Re: PA23-004 – Gamlam Subdivision – Technical Review 1

After preliminary review of the above referenced proposal, the Planning Division has the following comments:

SHEET DESCRIPTION: **PRELIMINARY PLAT**

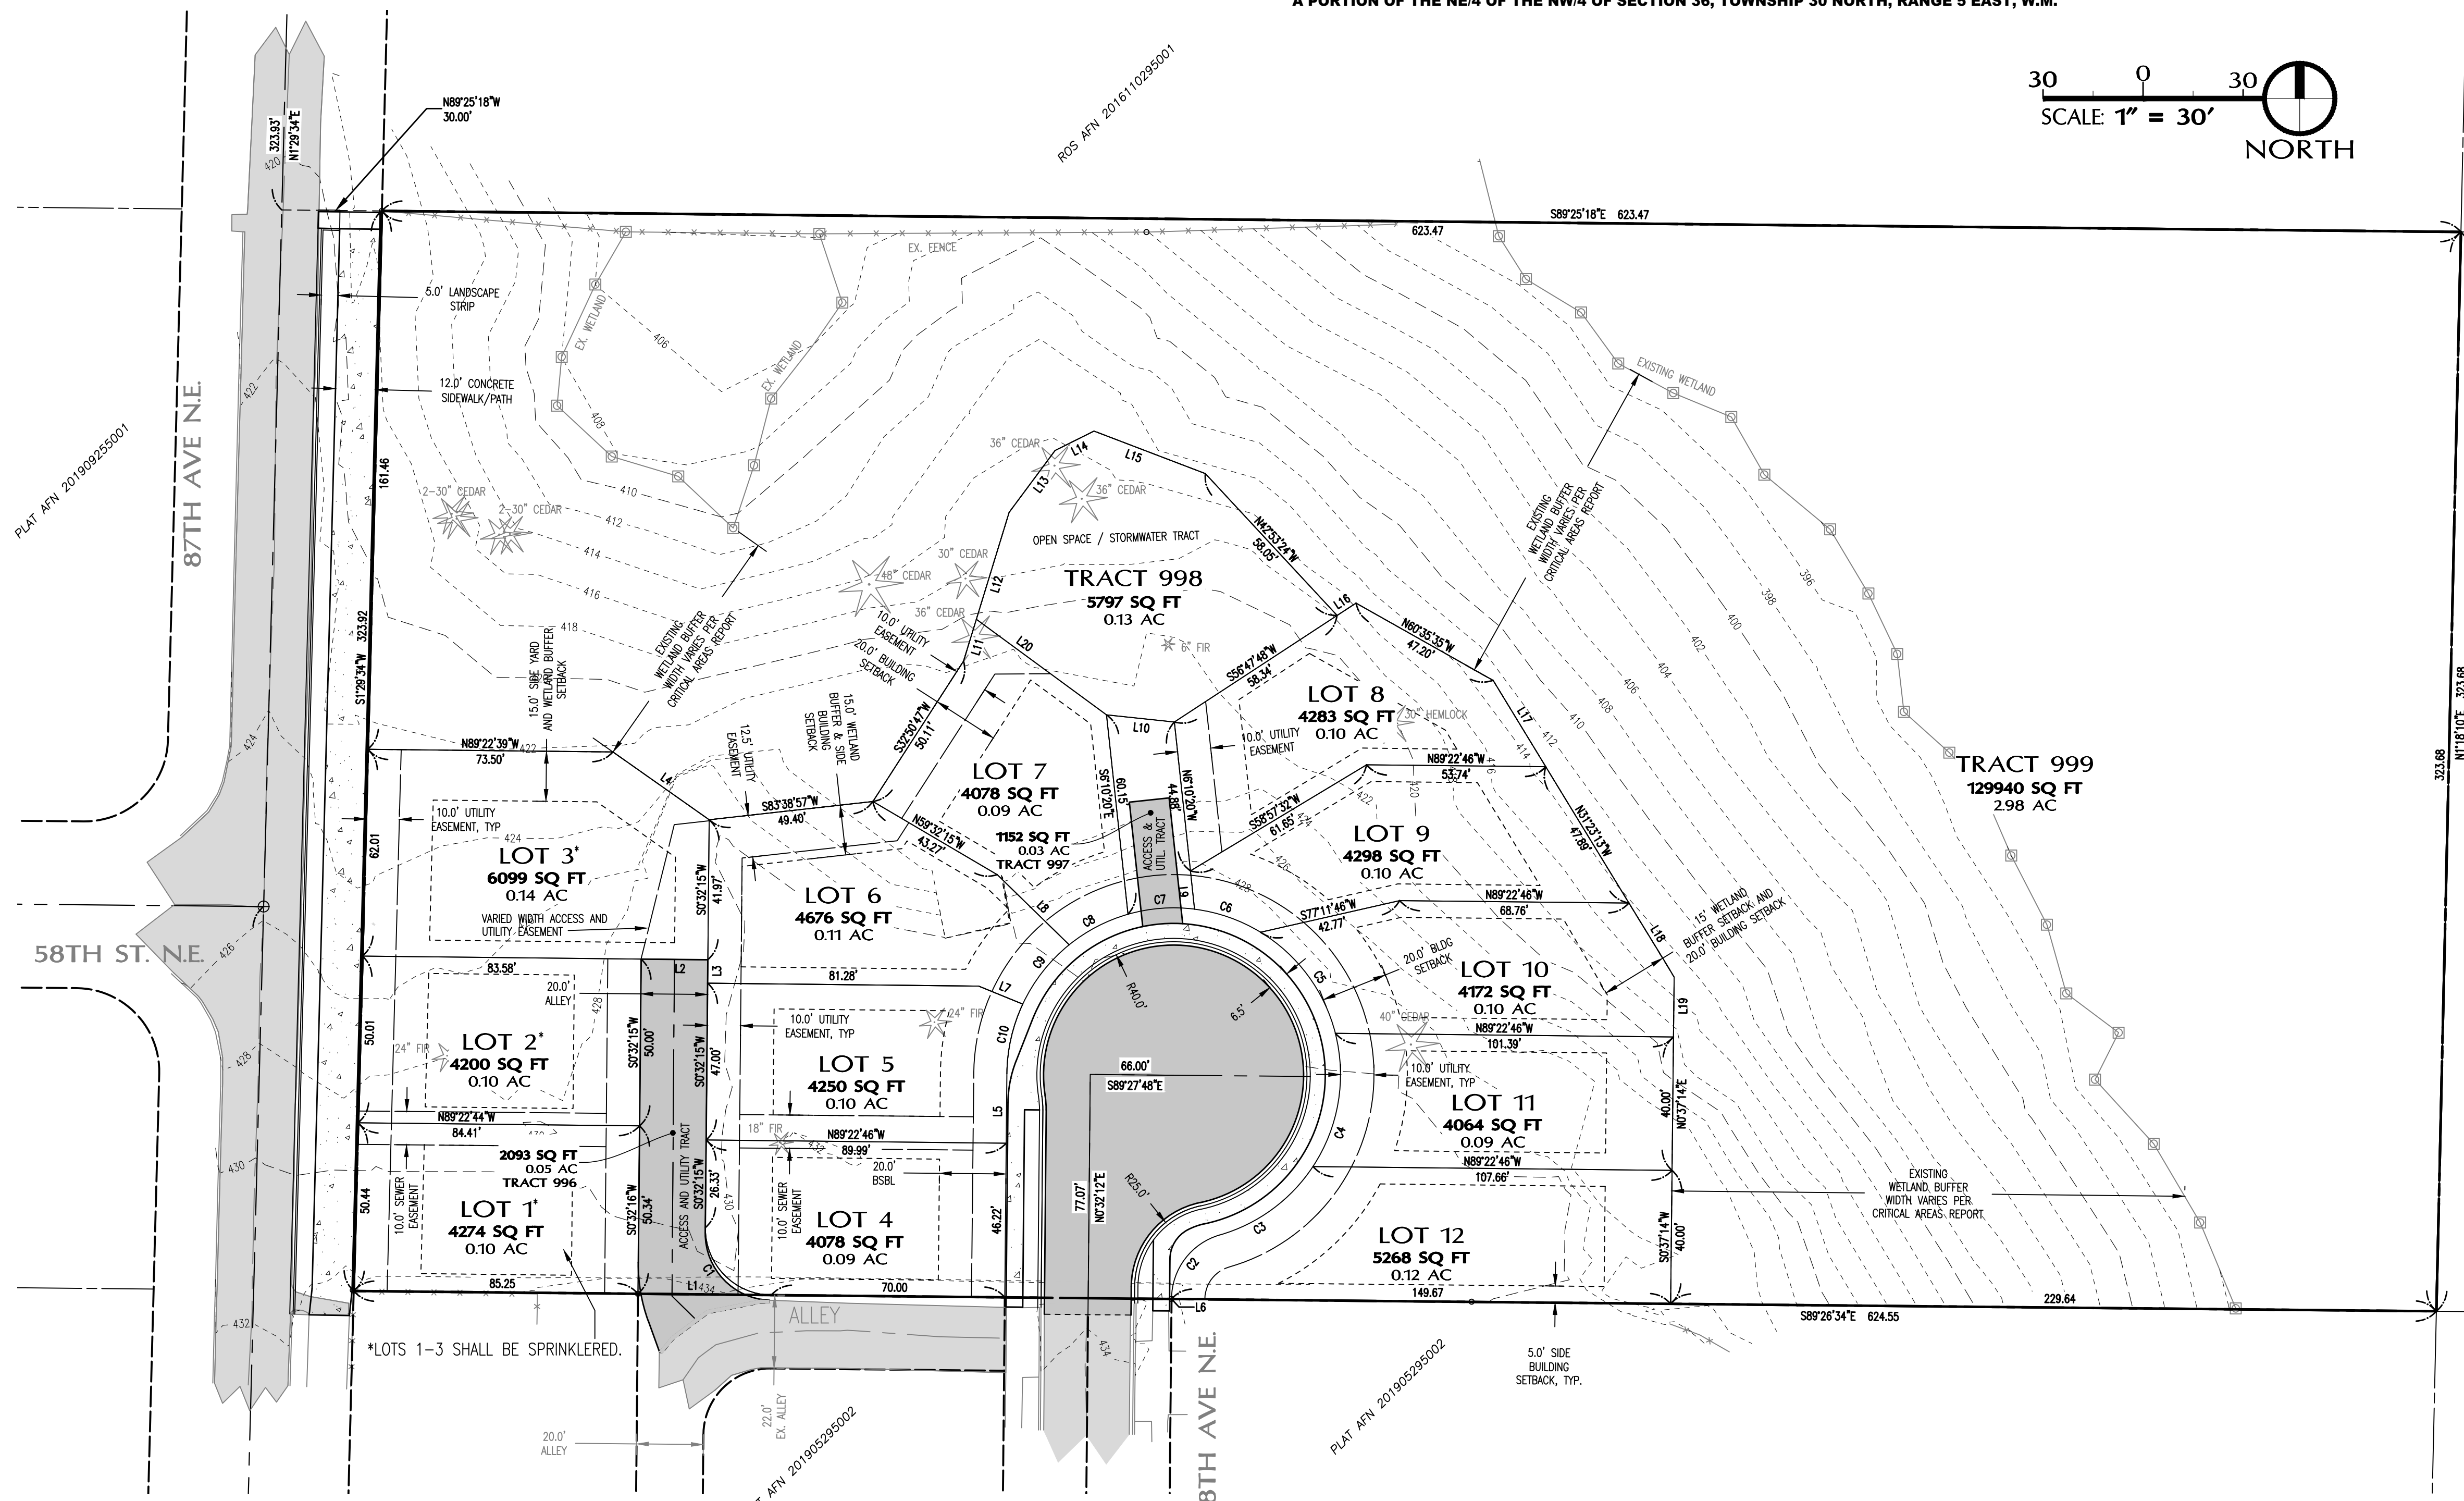
1. Include File Number PA23-004 on all future correspondence, in addition to all site, civil and landscape plans.
2. Please clearly delineate the wetland buffer (use bold or differing line weight/type) on the plat map. It should **not** be the same line weight/type as lot lines. Also see comments from Washington Department of Fish and Wildlife.
3. The note '15' Wetland Buffer Setback and 20' Building Setback' shown highlighted below, is confusing as it is shown as the same measurement; please remove.

4. Lot 9 does not appear to meet the minimum lot width of 40 feet. Lot width is the horizontal distance between the side lot lines measured on a line intersecting at right angles the line of the lot depth 30 feet from the front lot line. Please revise lot 9 to meet the minimum lot width.
5. The Geotechnical Report is labeled as 'Draft' in multiple locations. Please provide a final Geotechnical Report with the next submittal.
 - 5.1. Once a final Geotechnical Report is submitted, it will be reviewed and additional comments may be provided.
6. Amend civil plans to add the top and the base elevations for any/all retaining walls.

9. Consistent with MMC 22E.010.090(10), as well as comments received from Department of Ecology, Storm water management facilities, such as biofiltration swales and dispersion facilities, may be located within the outer 25 percent of wetland buffers only if they will have no negative effect on the functions and purpose the buffers serve for the wetland or on the hydrologic conditions, hydrophytic vegetation, and substrate characteristics necessary to support existing and designated beneficial uses. The proposed infiltration trench is very close to the wetland boundary, will within the buffer. Please relocate the facility to be wholly within the outer 25% of the buffer.

10. All portions of individual lot spreaders shall be fully on the private lots. Additionally, these facilities shall be set back 10 feet from property lines (reduction to 5-foot setback on a case by case basis).

14. What does the line highlighted below on lot 6 represent? Please review and revise accordingly.

- There was no SEPA checklist included in the materials in the public folder on the Marysville website. Was ecology notified of this project?
- The map labeled '1-plat' does not incorporate exact wetland buffer distances. On this plan, the buffers are labeled 'existing wetland buffer width varies per critical areas report'. Is there a reason why this distance isn't depicted accurately on site plans where construction design is outlined? It's outlined through the critical areas report map, but I'm not seeing it outlined where construction drawings are involved.

3. Is the stormwater facility a pond or bioretention? Please provide details and a planting plan with civil plan submittal.
4. Please move the dispersion trench closer to the facility and within Tract 998. Typical maintenance activities are not allowed in critical areas tracts.

5. The catch basin alignment from tract 996 to the facility is not ideal. As the grade will allow please minimize the number of catch basins that are located on private lots.
